**Christian Construction Inc. RHOC, AL-19-030**

**Please accept the following comments from El Paso County Public Health regarding the proposed equipment storage:**

IMPROVEMENT SURVEY PLAT

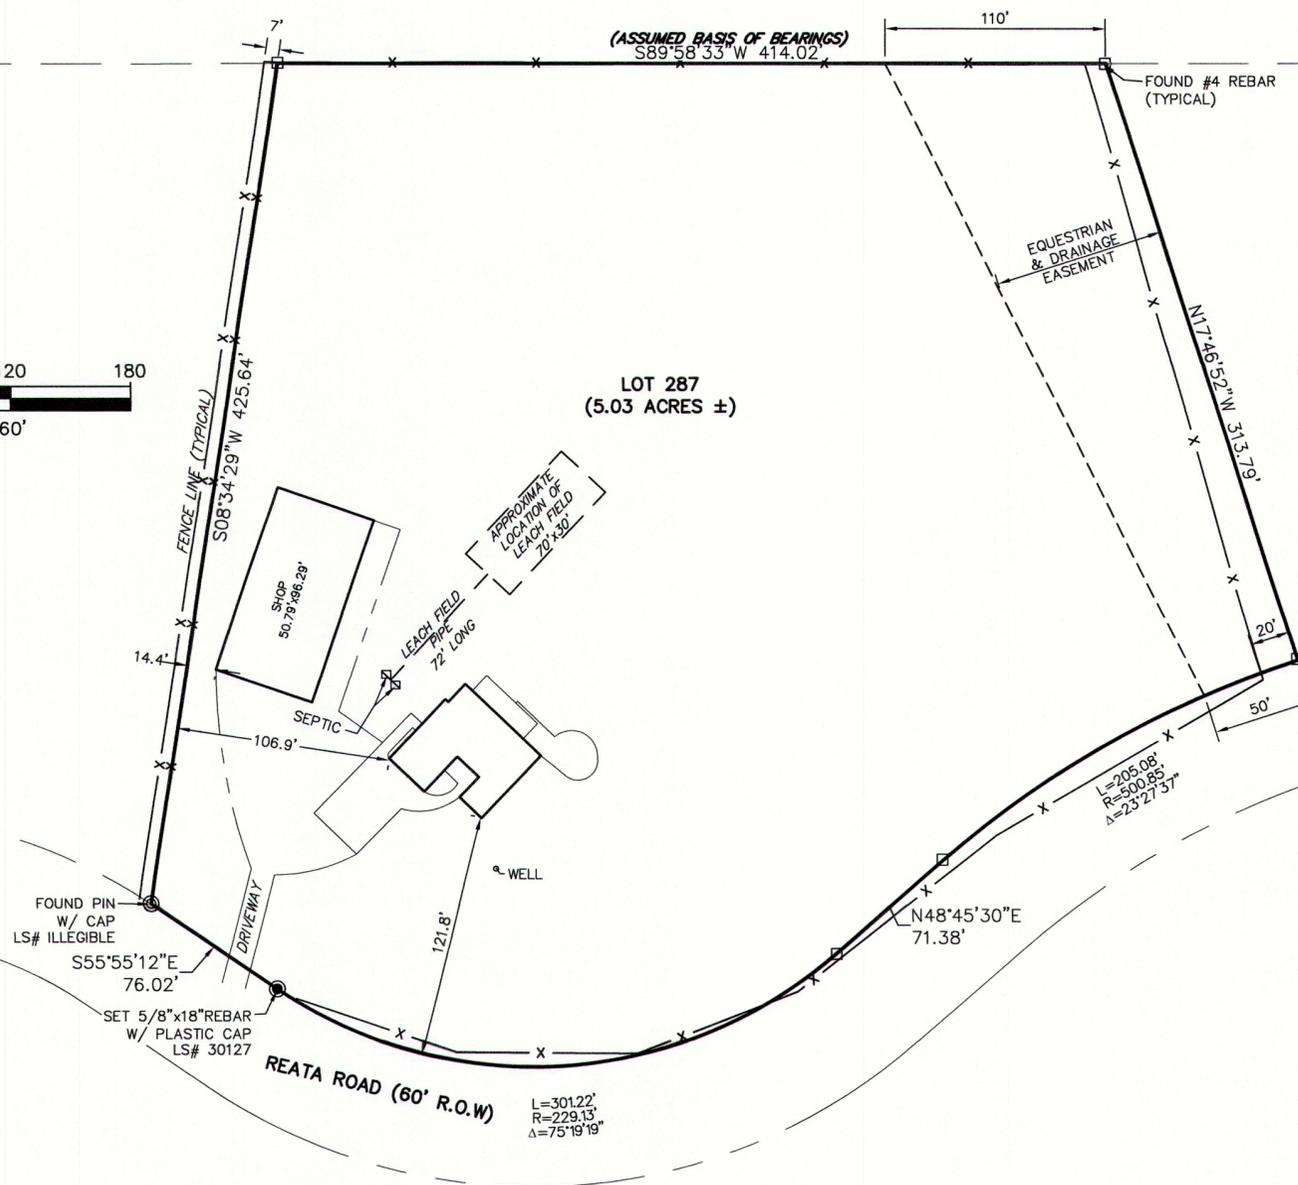
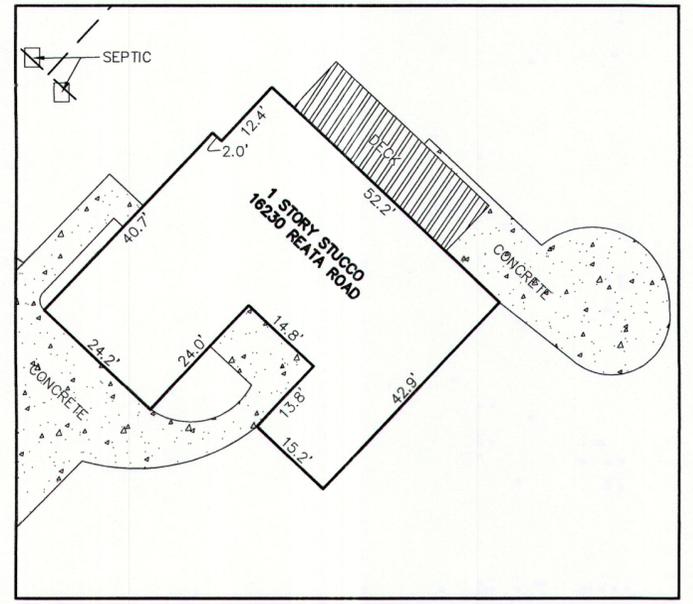
- **A record of a 1999 approved and permitted on-site wastewater treatment system (OWTS) for the existing house indicates the OWTS components are located slightly north and east of the house. Please make sure the existing OWTS septic tank, soil treatment area (STA) and an equally sized STA replacement area remain protected from vehicular damage by compaction. The septic tank is an approved plastic tank but is not traffic rated. The STA is not designed to be driven over and compaction will result in early system failure.**
- **Please locate the existing OWTS components and protect them in some manner from being compacted.**
- **No other public health issues noted with the proposal.**
